STATE OF WASHINGTON
DEPARTMENT OF ECOLOGY

March 21, 2019

Re: Hou Critical Areas Determination
File Nos.: CAO17-010 and SEP19-003, Ecology SEPA #201900882

**CRITICAL AREAS MITIGATION PLAN
 PROPOSED SITE PLAN, IMPACTS & MITIGATION PLAN
 HOU PROPERTY
 MERCER ISLAND, WA**

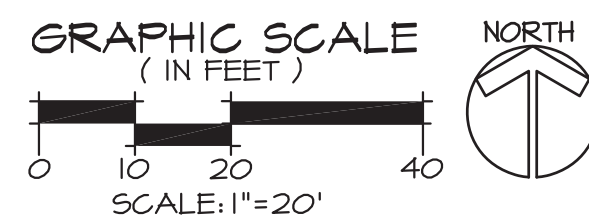
Ecology would regulate the wetland as a water of the state subject to the applicable requirements of state law (see RCW 90.48 and WAC 173.201A) and Section 401 of the Clean Water Act (33 USC §1341) and 40 CFR Section 121.2. We are concerned about the buffer encroachment and do not support building the house so close to the wetland. This is not consistent with Ecology guidance on buffer widths in Wetland Mitigation in Washington State – Part 1: Agency Policies and Guidance (Publication #06-06-011a).
